Boston Alternative Energy Facility

Fourth Report on Outstanding Submissions

Planning Inspectorate
Reference: EN010095

Document Reference: 9.90

- Key**
- Order limits
 - Habitat Mitigation Area
 - Land outside Order limits
- Footpath Status**
- Existing to be retained
 - Public Rights of Way (to be stopped up permanently)

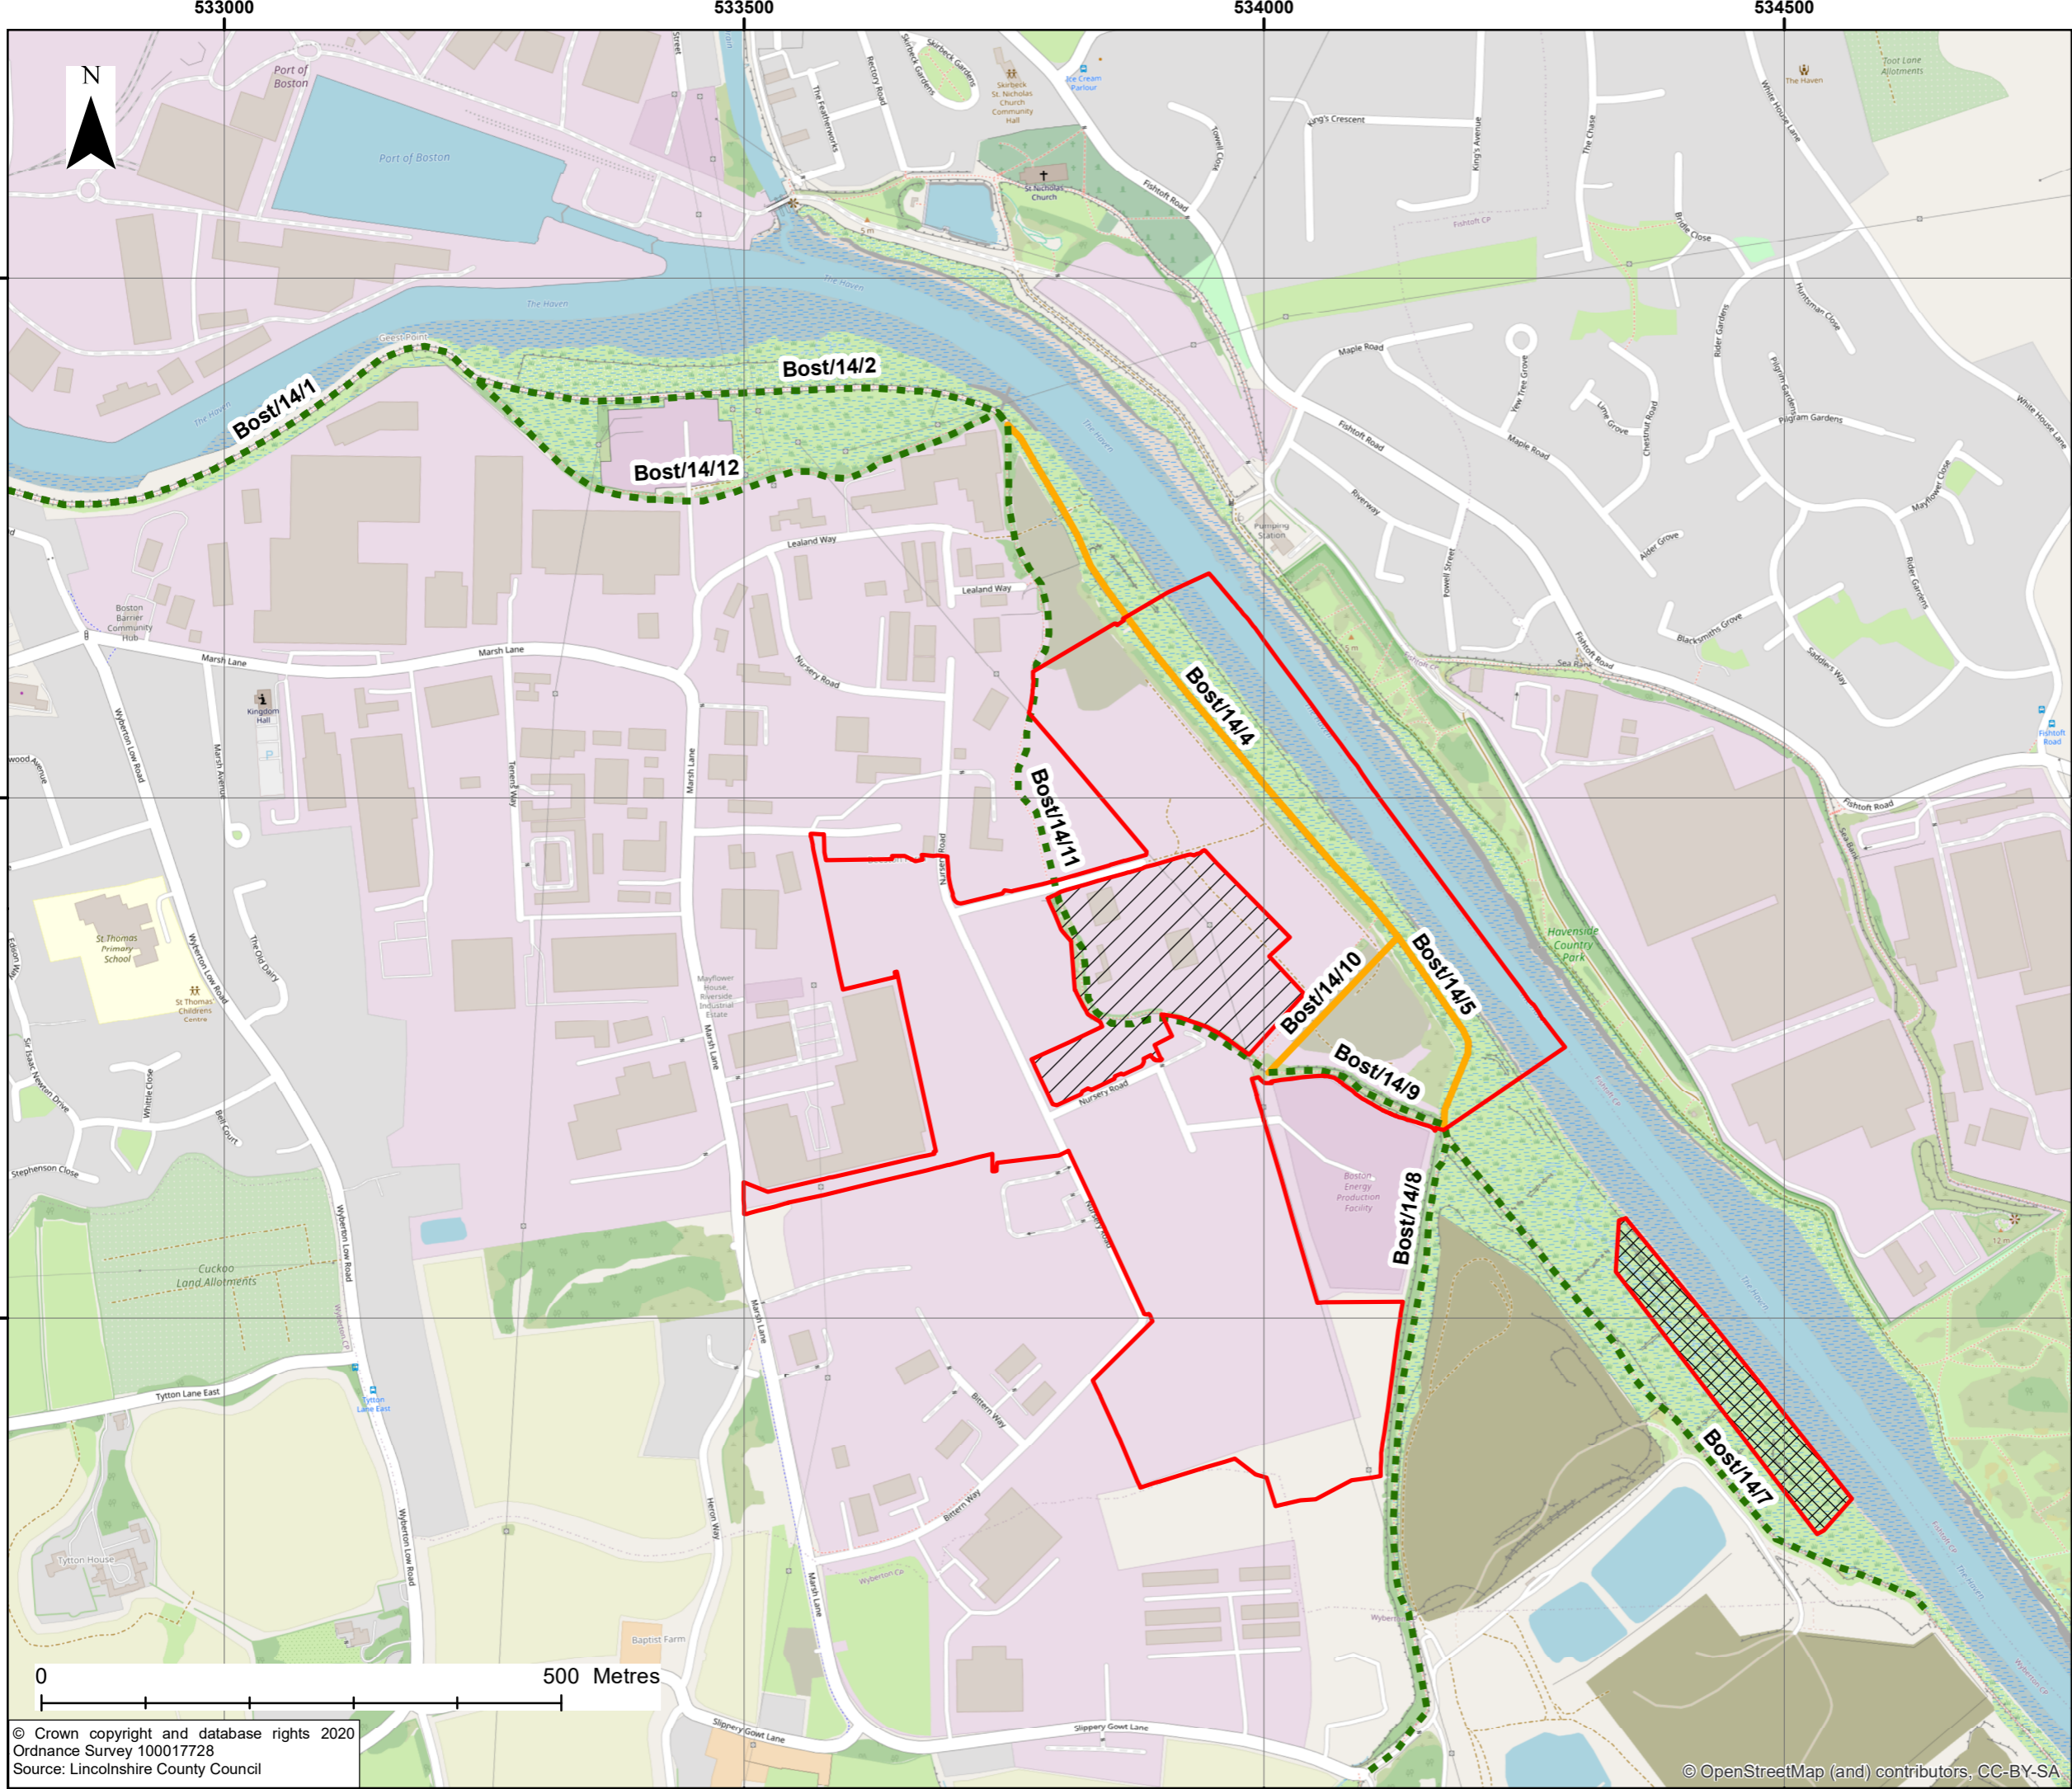
No.	Comment	The Applicant’s Response
1	<p>Para No. 3.2.5.</p> <p>NE continues to request further clarification on the proposed Habitat Mitigation Area - in particular regarding the removal of the low-profile banks. We specifically require details of where the bank will be removed, the method, a calculation of the volume of material to be removed and where this will be disposed of. In addition, the location of the created 3 shallow pools and methods used.</p> <p>Also, regarding the placement of rocks from the Principal Application Area to the proposed Habitat Mitigation Area - to facilitate roosting of Redshank - will these function in the same way as the remaining banks (Old sea wall) that is presumably not being removed? This may restrict visibility of predators.</p> <p>Natural England suggest one additional mitigation option here: restricting access by Members of Public and dog walkers onto the Habitat Mitigation Area from the Coastal Path using fencing. This would minimise disturbance if this area is being used more regularly by roosting birds. Signage actively asking Members of public to keep dogs on the lead (and why this habitat is important) would be beneficial.</p>	<p>The Applicant has responded to all questions raised on the Habitat Mitigation Area within the responses sent through during the examination process. The updated OLEMS document (document reference 7.4, REP7-037) states that “The plans for the works would be developed to provide optimal benefits for biodiversity, in discussion with Natural England, the Environment Agency and the RSPB.” This is to ensure that any works are undertaken with the objective of improving the area for birds and other wildlife and to ensure that no works would be undertaken that would have an adverse effect.</p> <p>The habitat mitigation works are not expected to change the access by members of the public and dog walkers from the existing usage in this area and this is not considered to be an issue due to the width of the habitat in this area.</p>
